Architectural Design Report - Response to Submission

# UNSW Health Translation Hub

This report has been prepared on behalf of UNSW as an addendum to SSD 10822510 for the Health Translation Hub building.

The report has been compiled to respond to the design-related submissions received by the Department of Planning and Environment and Randwick City Council during the public exhibition of the UNSW HTH.

scale	1 : 250@A1	drawing no.
drawn	TH	DA2004
checked	JC	issue
project no	190551.00	B

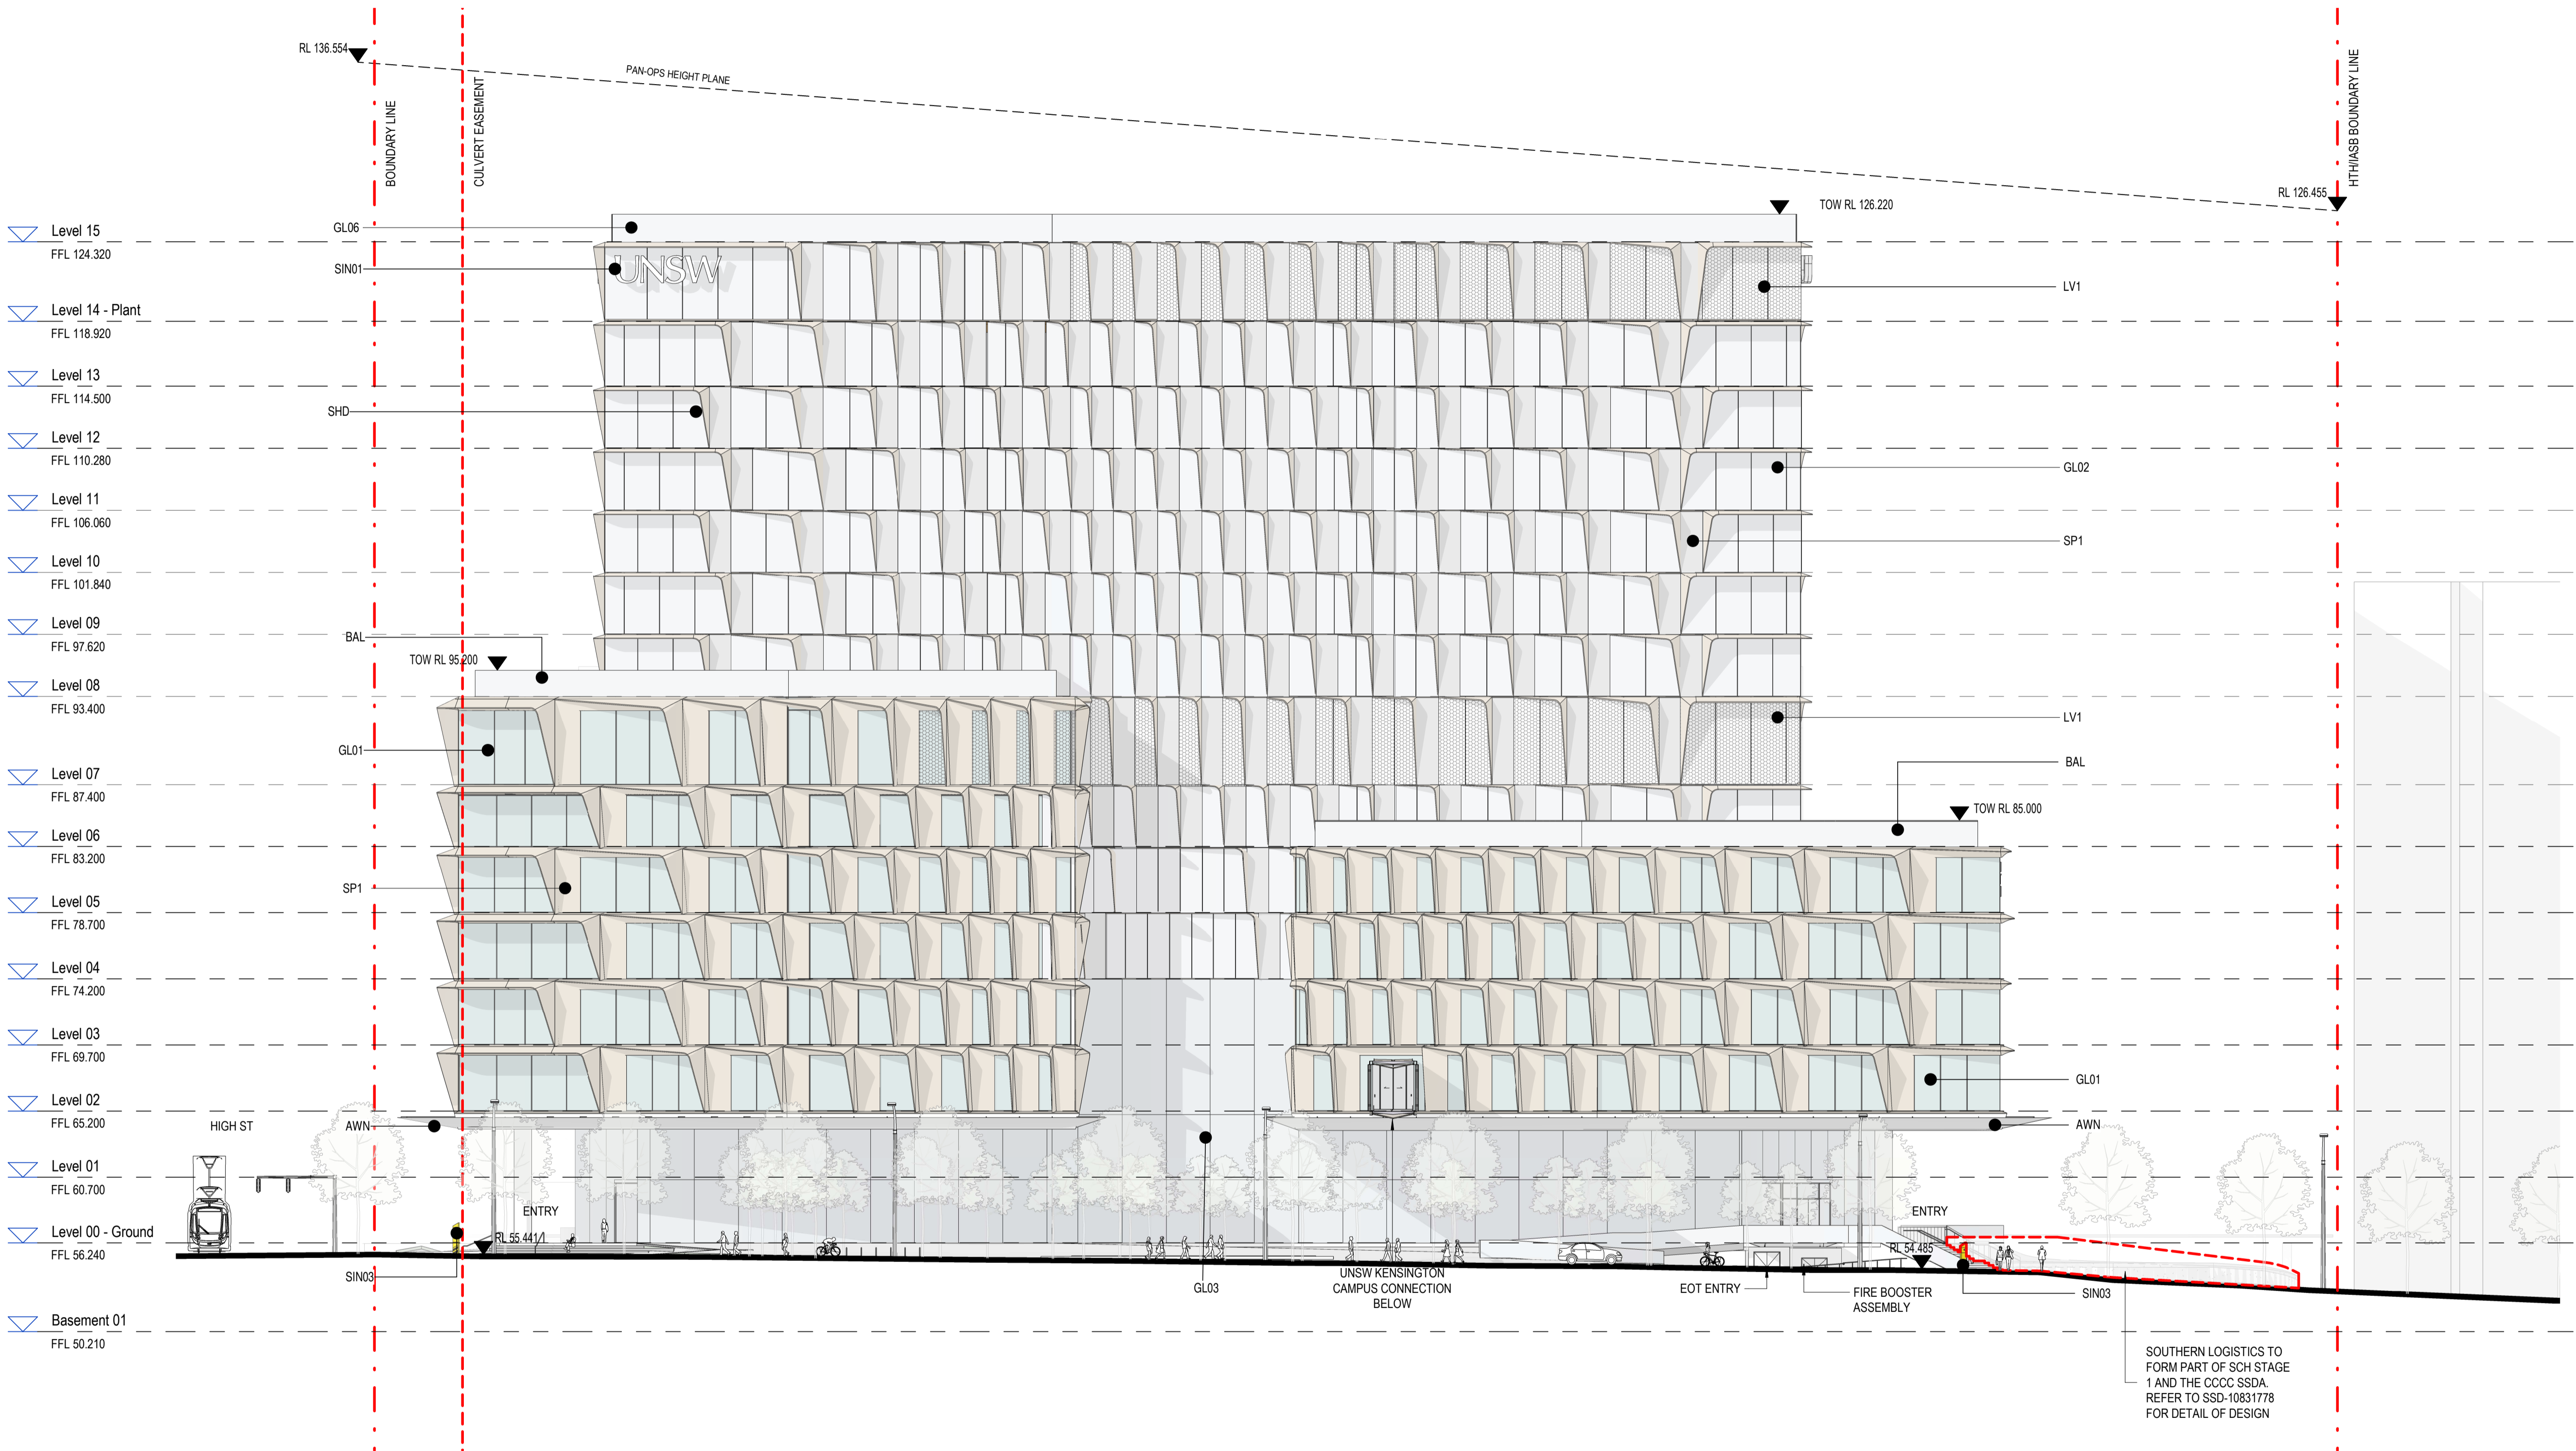
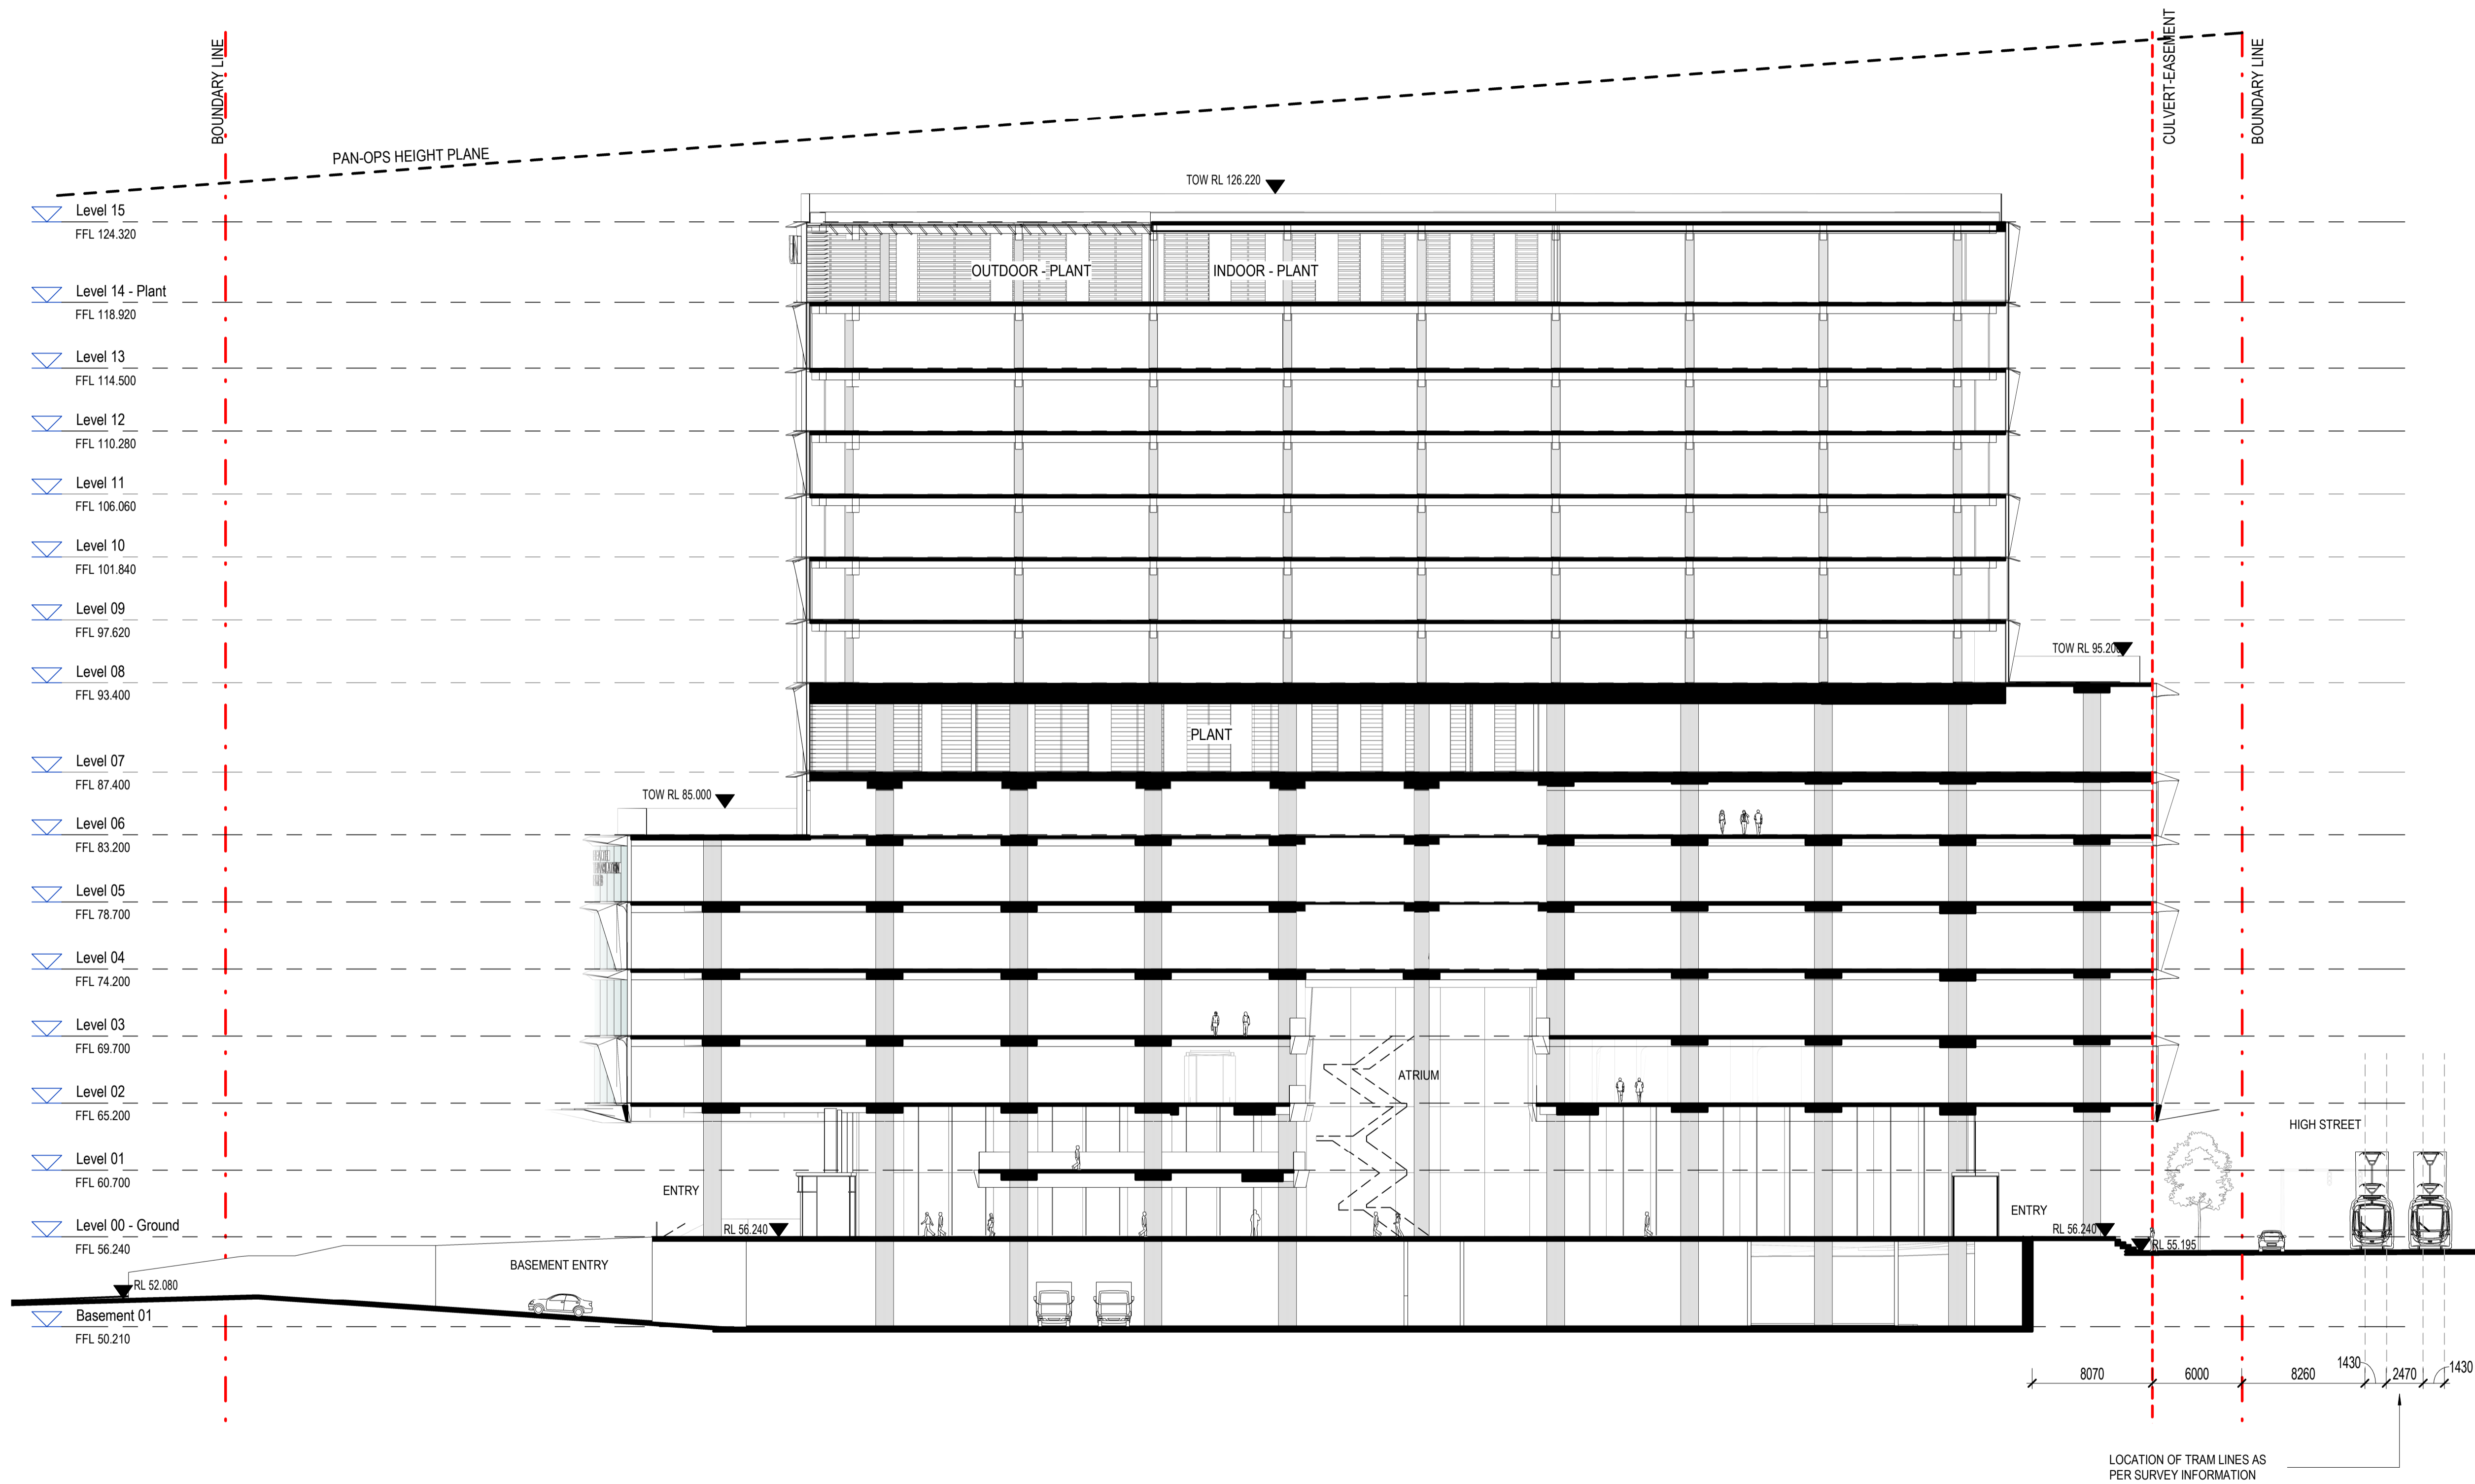
*Further consideration should be given to the design of the airbridge connection to the proposed SCH Stage 1 and CCCC building, having regard to previous advice from the State Design Review Panel on the proposal and the adjoining proposal.*

With reference to the most up-to-date façade design for the SCH Stage 1, the UNSW HTH design team proposes to remove the solar hoods - that previously extended along the airbridge connection - to provide an un-adorned elevation to the airbridge that is characterised by the transparency of its glazing. To reinforce the neutrality of the airbridge, the northern facade has been recessed to further separate the building facades and give emphasis to the airbridge's legibility and purpose as a linking element in the composition of building forms.

This design refinement has been illustrated in the adjacent images and updated elevations in attachment A.
